Application no: H11-0665-10

Description: Joinery details (Condition 5 of H11-0398-10)

Location: 6 Market Street
Long Sutton
Spalding
Lincs
PE12 9DF
PE12 9DF

Amendment: Amendment to show 2 glazed panels to top of
replacement door (dwg. no. 2133/05.A)

All softwood to be painted, colour to be agreed

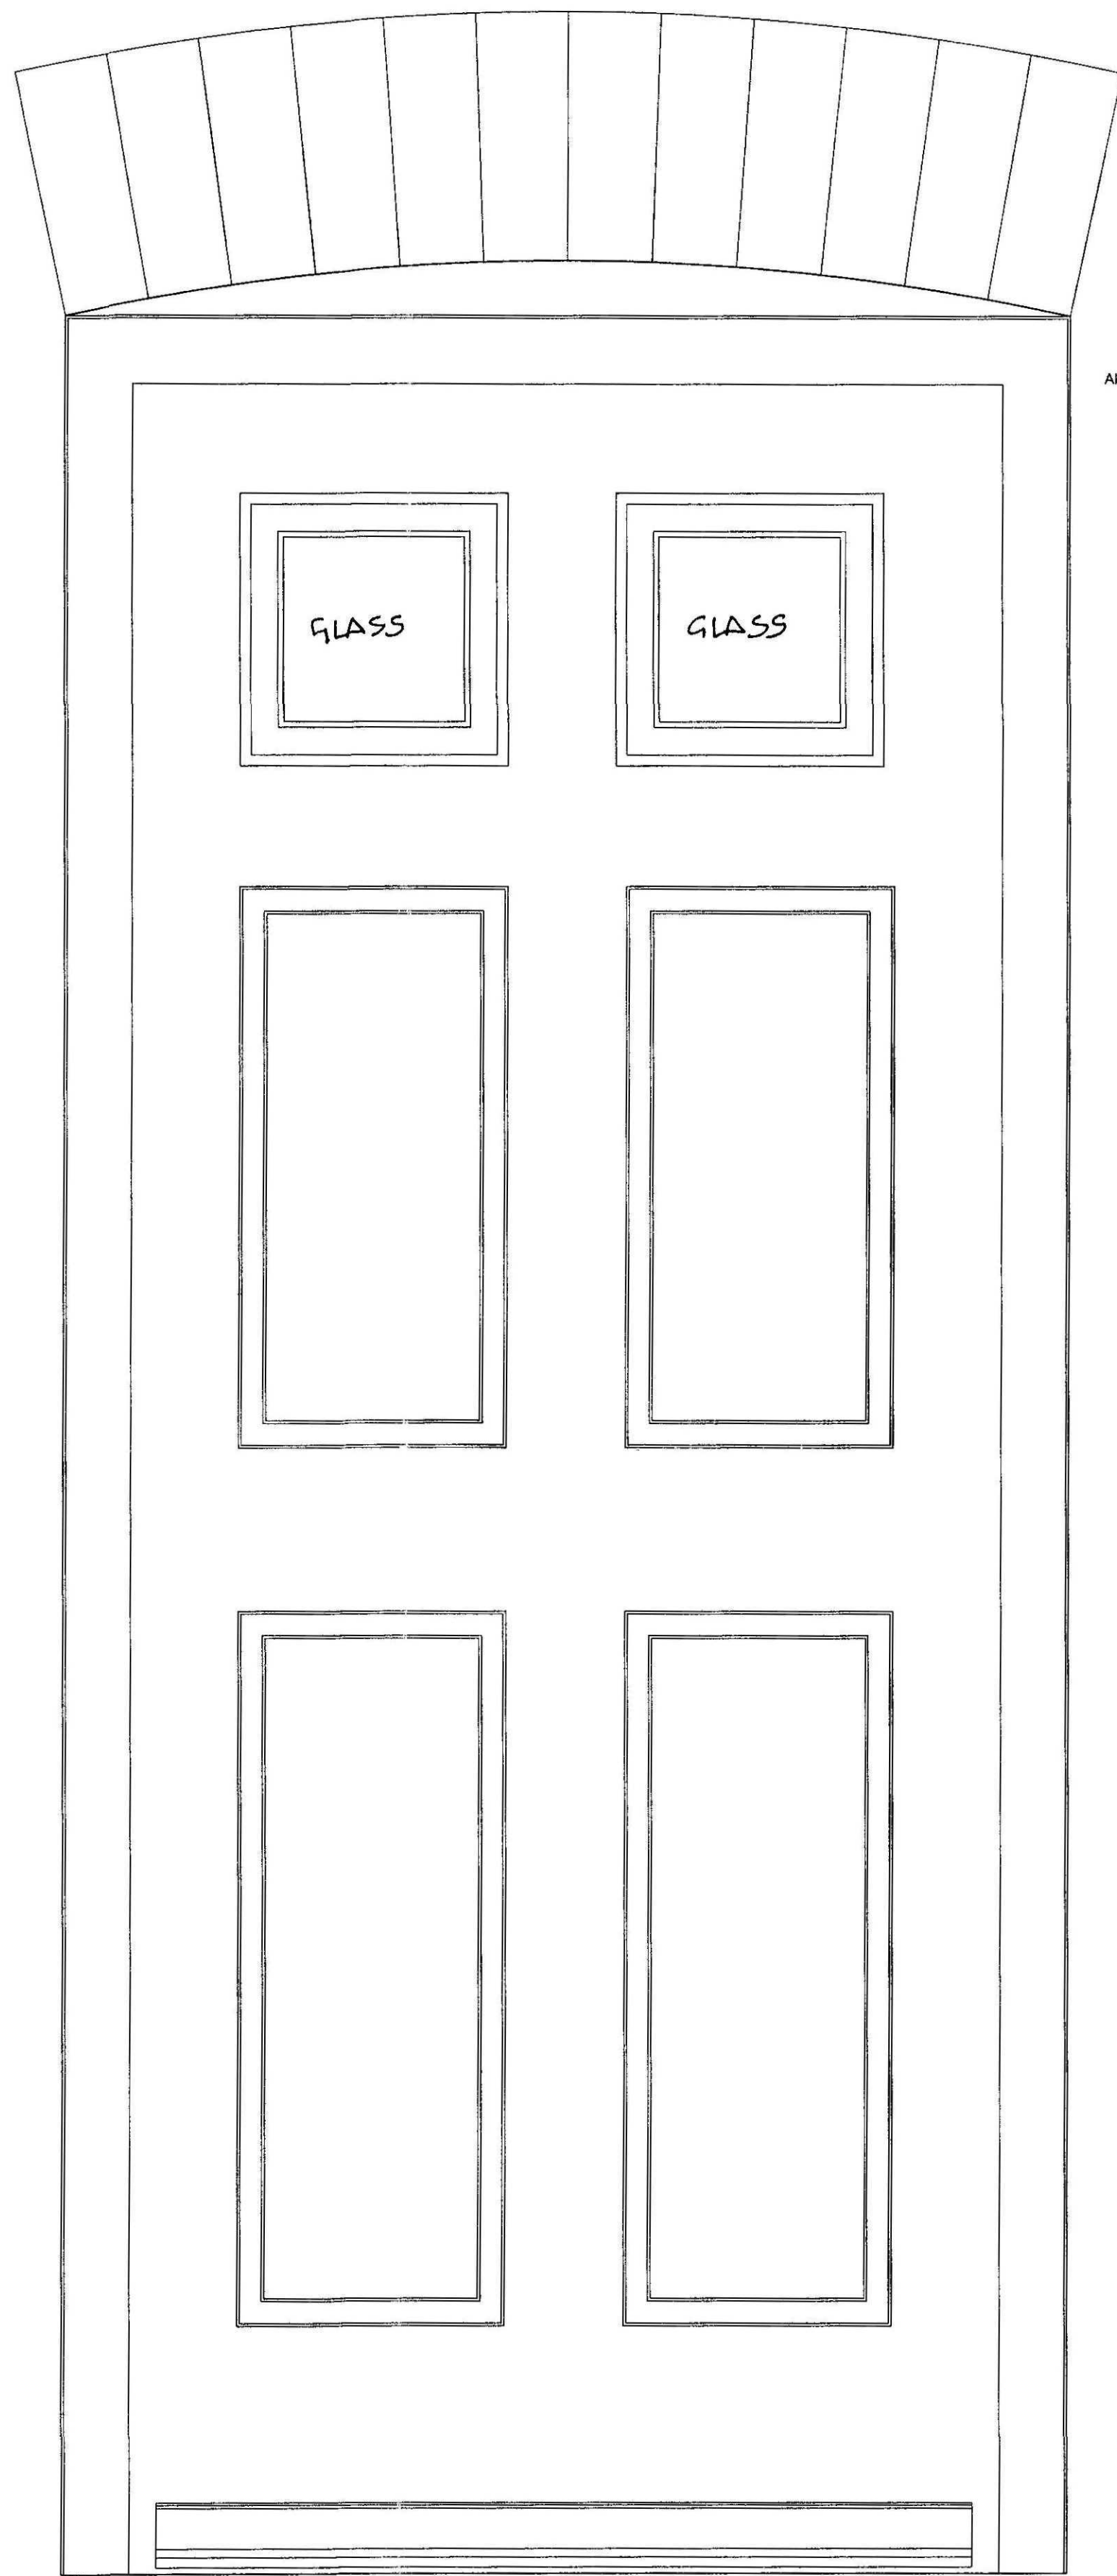
Further to the writer's telephone conversation with Mrs Middleditch on 6th September 2010 we enclose one copy of our Drawing No. 2133/05A indicating 2 no. glazed panels to the top of the replacement door (DG3) and note that this amendment is acceptable to you.
